Address: 20 Crowlees Road Mirfield WF14 9PJ

Application number: 2024/90610	
What is the application for?:	Demolition of existing bungalow and erection of two storey dwelling
Address of the site or building:	22, Crowlees Road, Mirfield, WF14 9PJ
Postcode:	WF14 9PJ

TITLE
PROPOSED GA PLANS

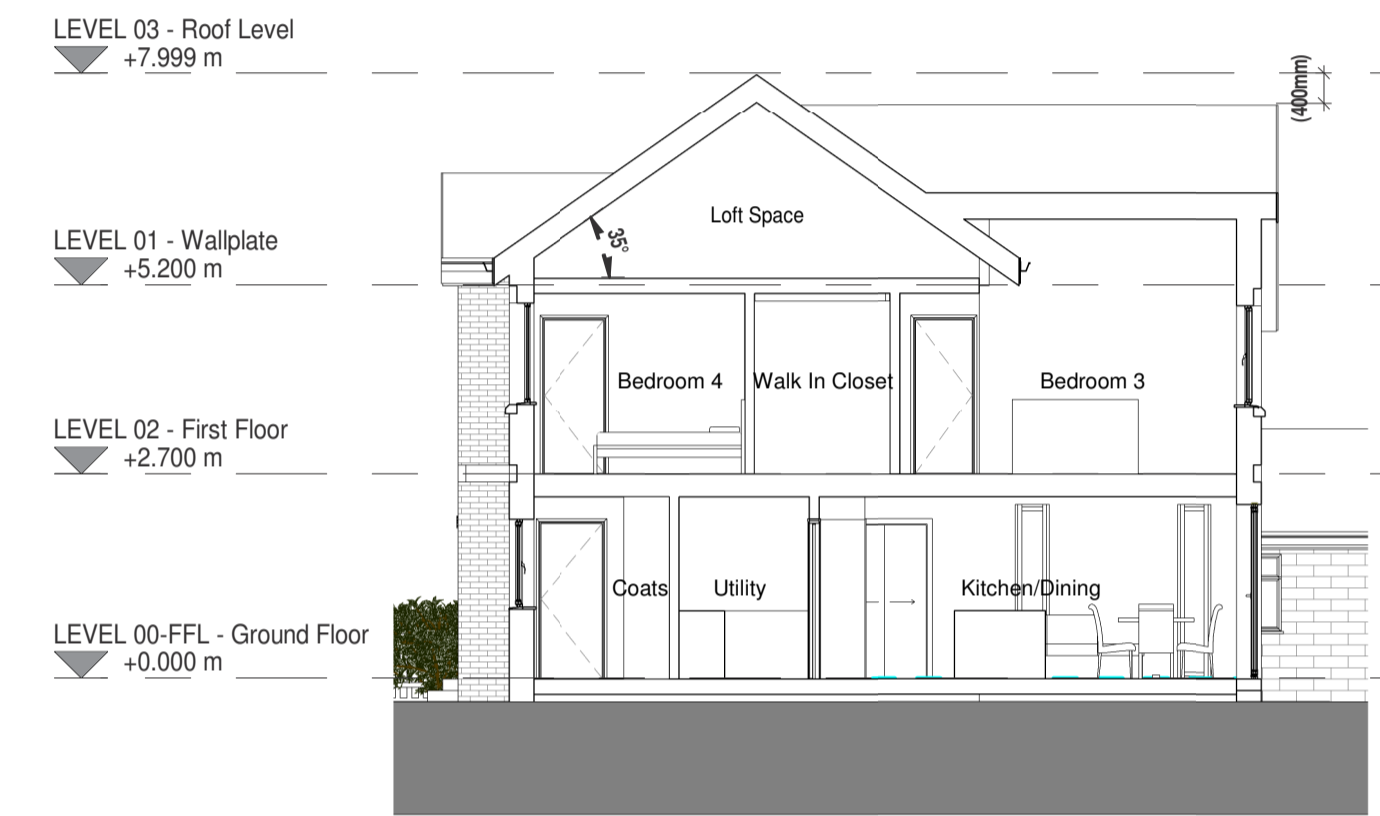
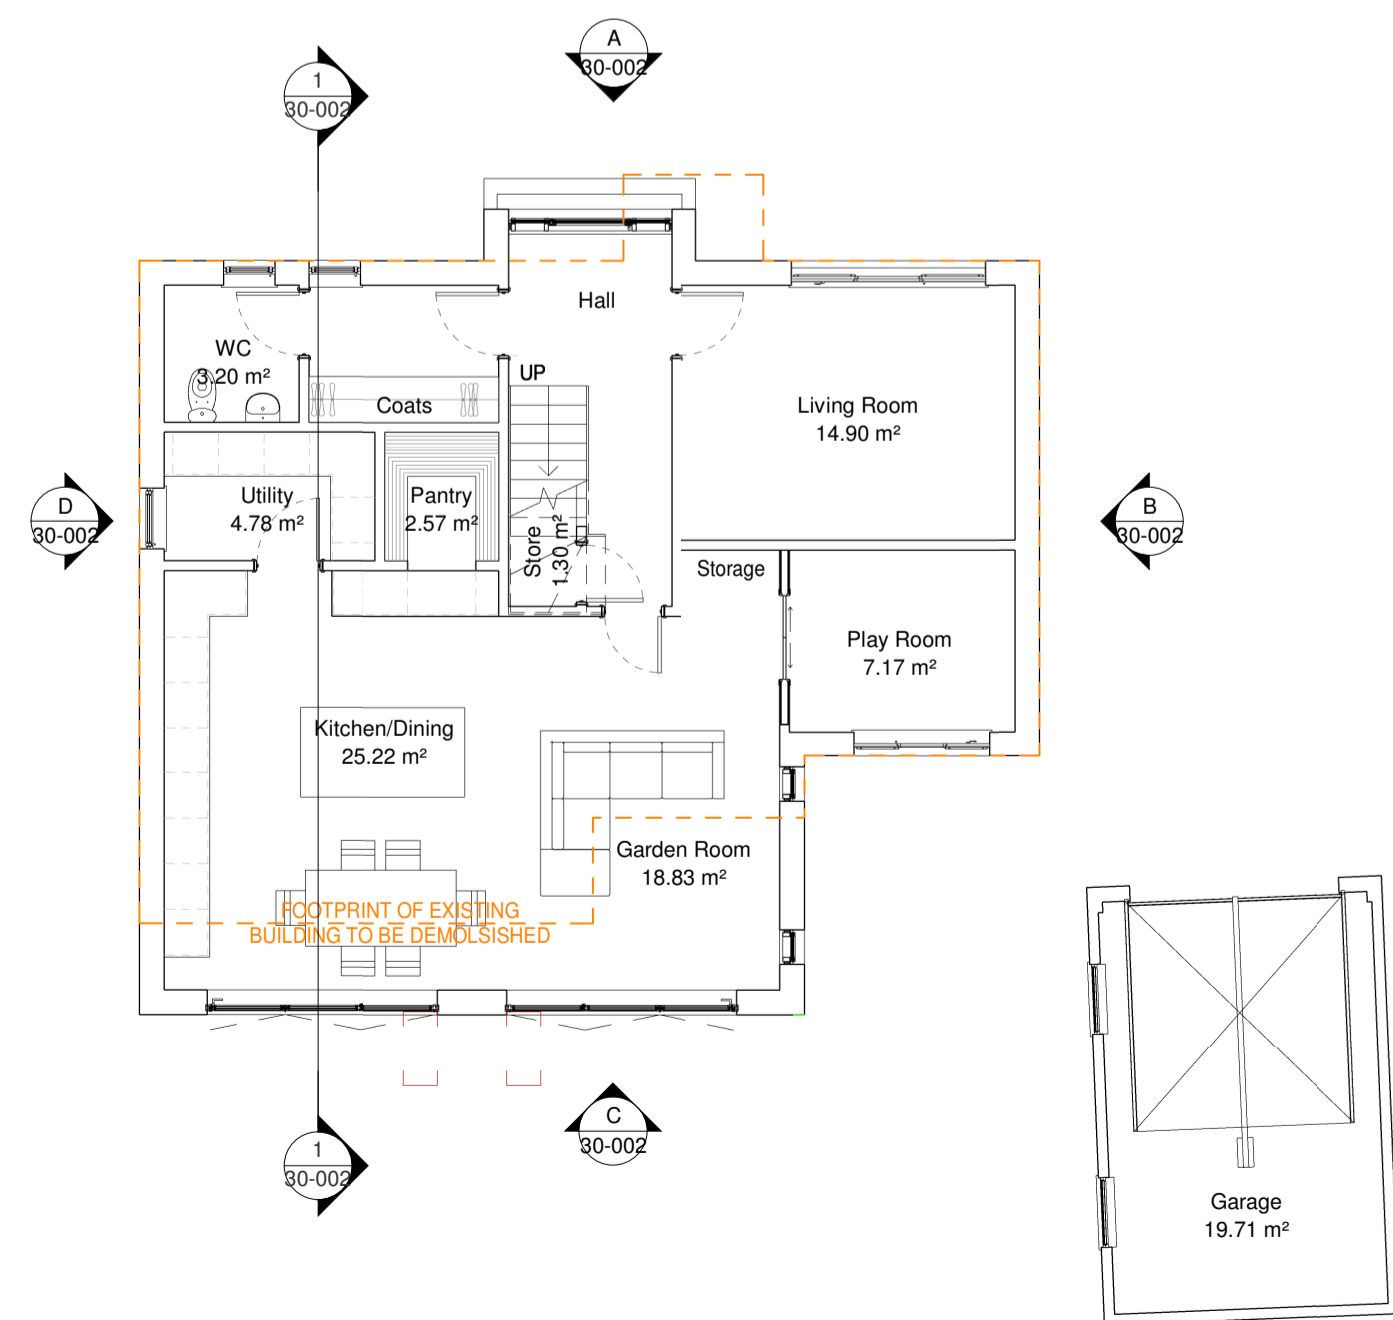
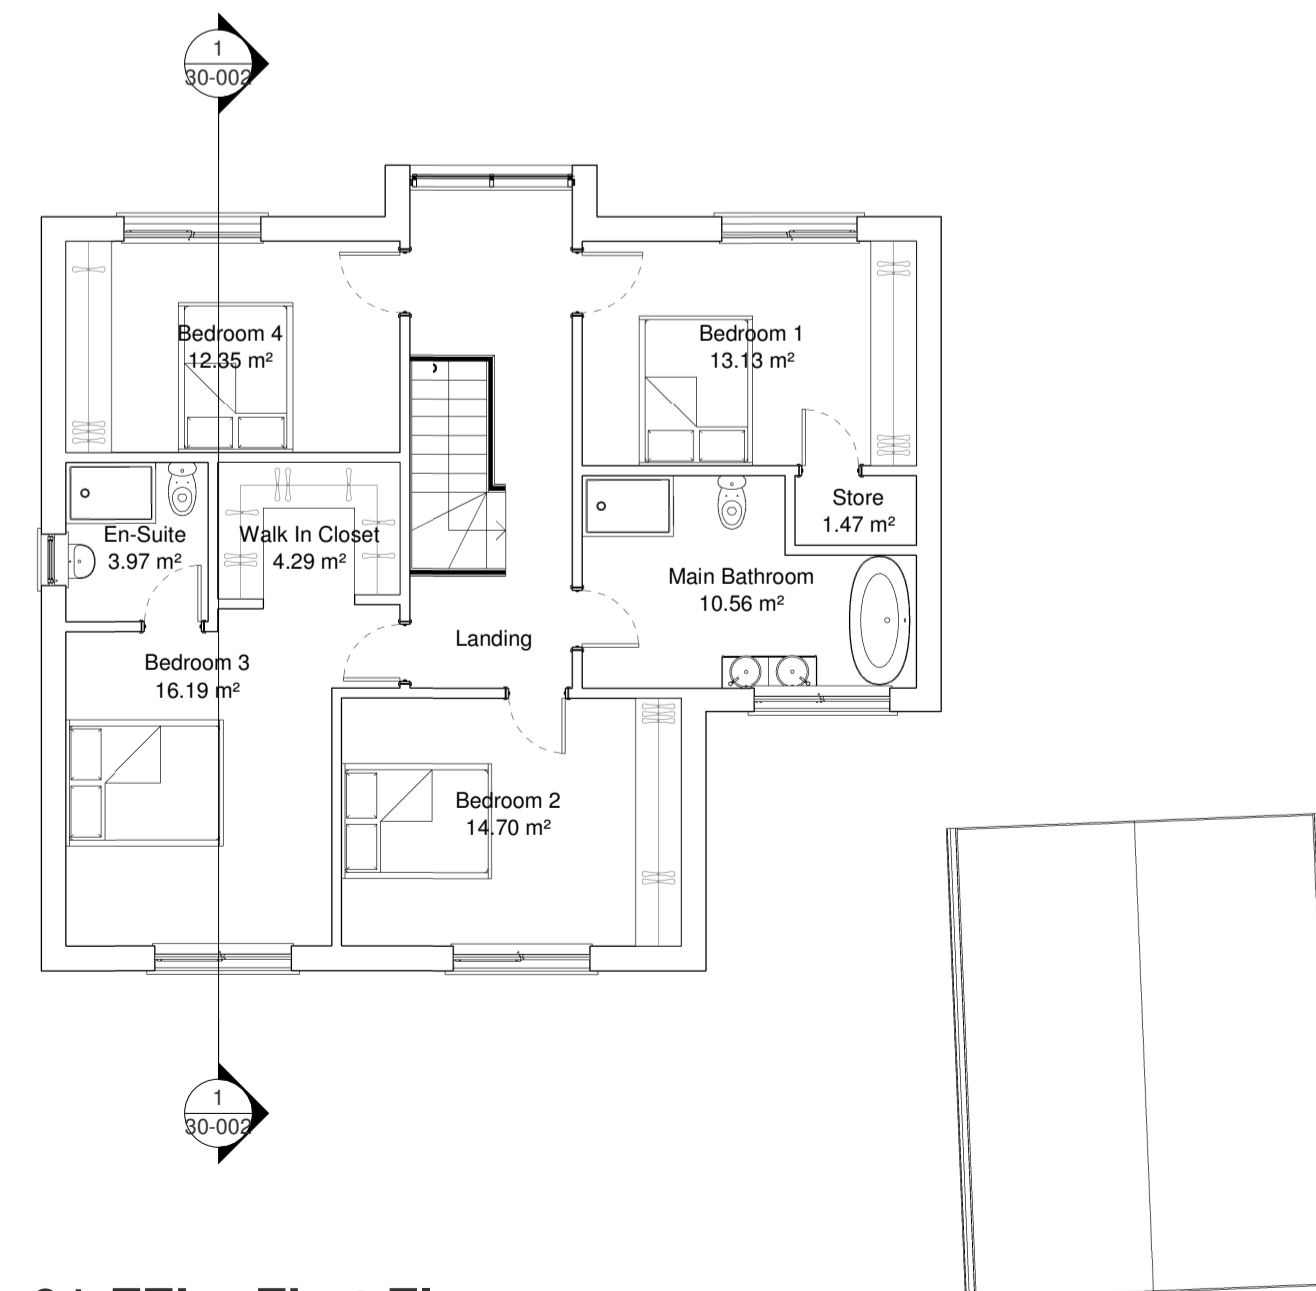
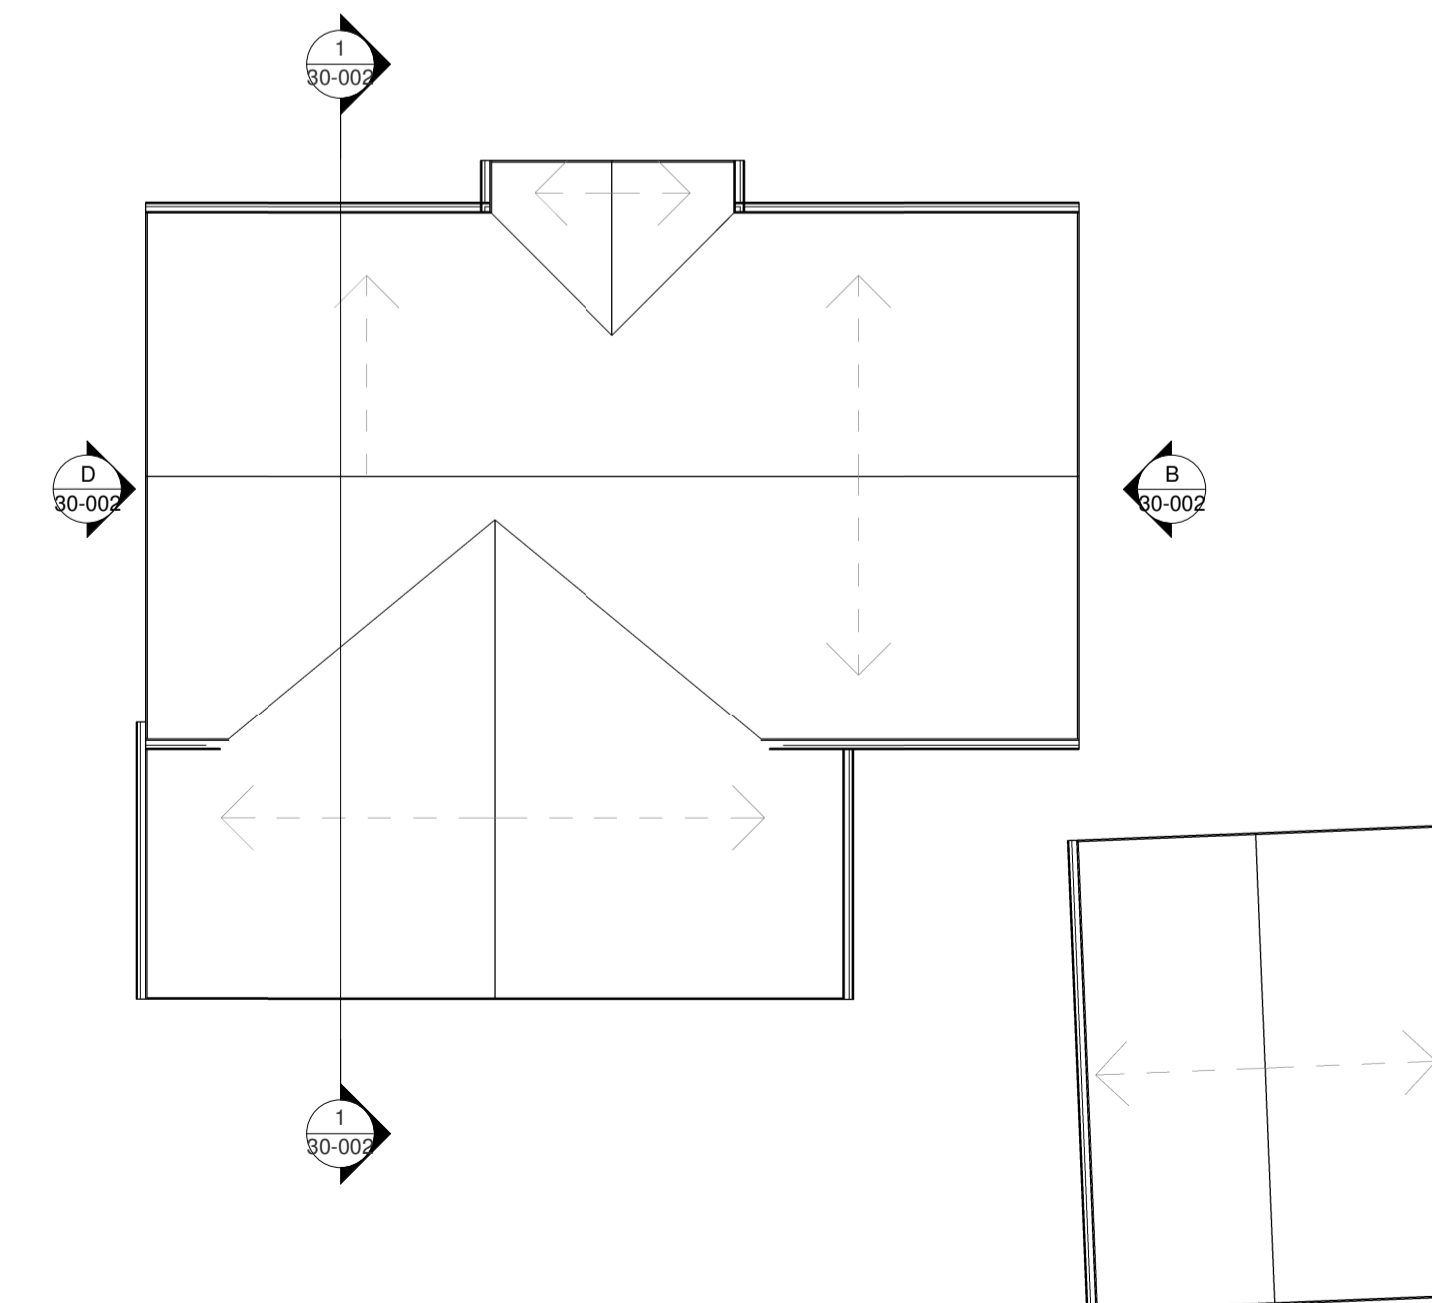
Type of comment: An objection	
Do you wish your comments to be published on the website anonymously?	No
<p>Firstly, none of the drawings submitted for this application have been pre approved. The previous application 2023/62/93151/E was approved with HIPPED ROOF as per the decision notice states Erection of an additional storey to the existing dwelling, hip to gable, roof extension and rear extension with external alterations. Please submit drawings that reflect what you intend to build with the hipped roof, not drawings which have not been approved.</p> <p>Without the hipped roof this would be totally overbearing and overshadowing and we would loose light to our habitable rooms with the velux as well as others.</p> <p>As per your supporting Statement states "Just for clarity, the plans remain the same as the approved plans" is totally rubbish and you should submit drawings which actually reflect what has already been approved and what you intend to build. That would be clarity.</p> <p>Further more, I am now concerned about potential problems with regards to the foundations and to what extent they may impact us, not knowing the design and nature of the proposed foundations and the coal mining risks, further details and reassurance from the council on this matter would be appreciated.</p> <p>As per our original concerns regarding the overlooking element and the raised patio areas, I would like a condition imposed that now or in the future no raised patio or decks can be installed/built on the rear which would allow for our piece of mind from being overlooking and imposing feel to our loss of privacy.</p> <p>Also that provisions are put in place to prevent noise, disturbance and dust from the work by scaffold netting or hoardings as the work is within 6ft of our property.</p>
